**Consultation Response from KC,
Lead Local Flood Authority**

2025/90689 Penistone Road/, Rowley Lane, Fenay Bridge, Huddersfield, HD8 0JS

Discharge of details reserved by conditions 16 (temp drainage), 25 (retaining walls), 26 (surface water attenuation pipes), 31 (road network) on previous permission 2020/92307 for outline application, including the consideration of access, for erection of residential development (up to 75 units)

**Date Responded: 11th April 2025
Responding Officer: Paul Farndale
Responding Ref: 1**

Appendix A

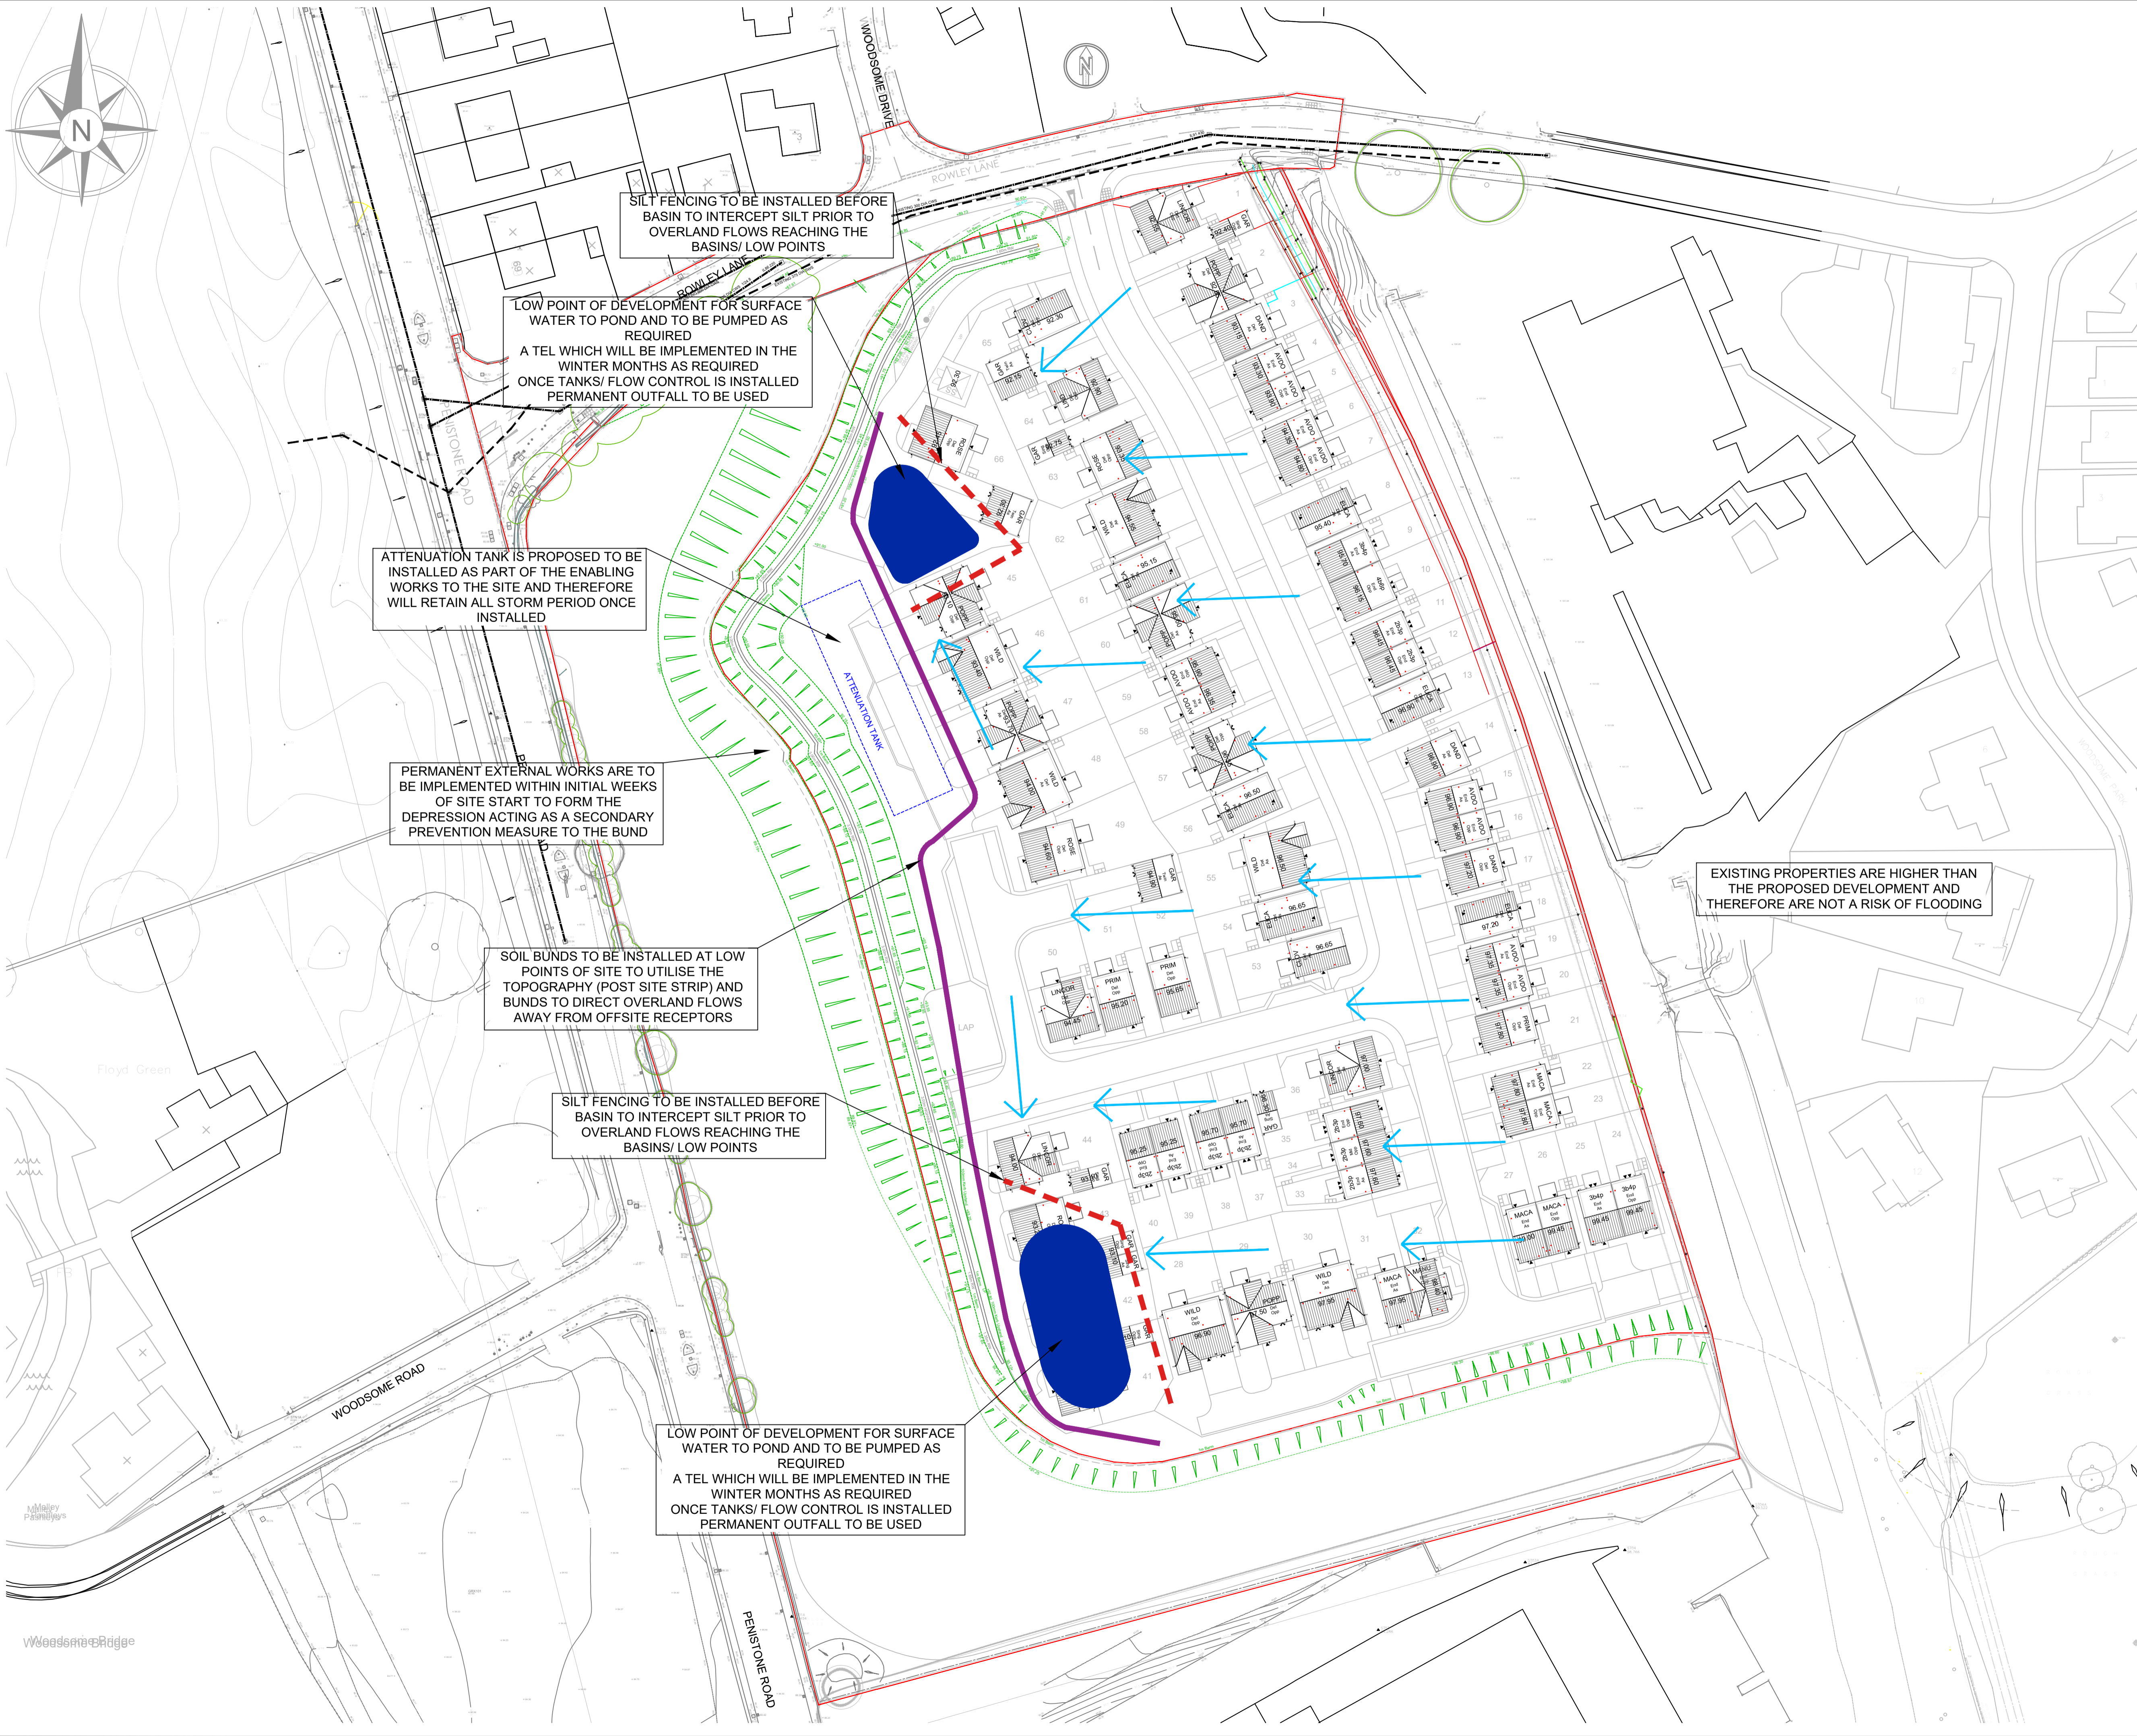
Condition 16 – Temporary Drainage

This condition primarily related to how the site copes with run off during the construction phase and retains a 60 minute-2 year storm on site and prevents off site flooding and pollution. This plan should fit in with the construction phases. However, there will need to be a clear distinction of how pollution prevention is done before and after mains drainage is installed.

We advise that this condition NOT be discharged.
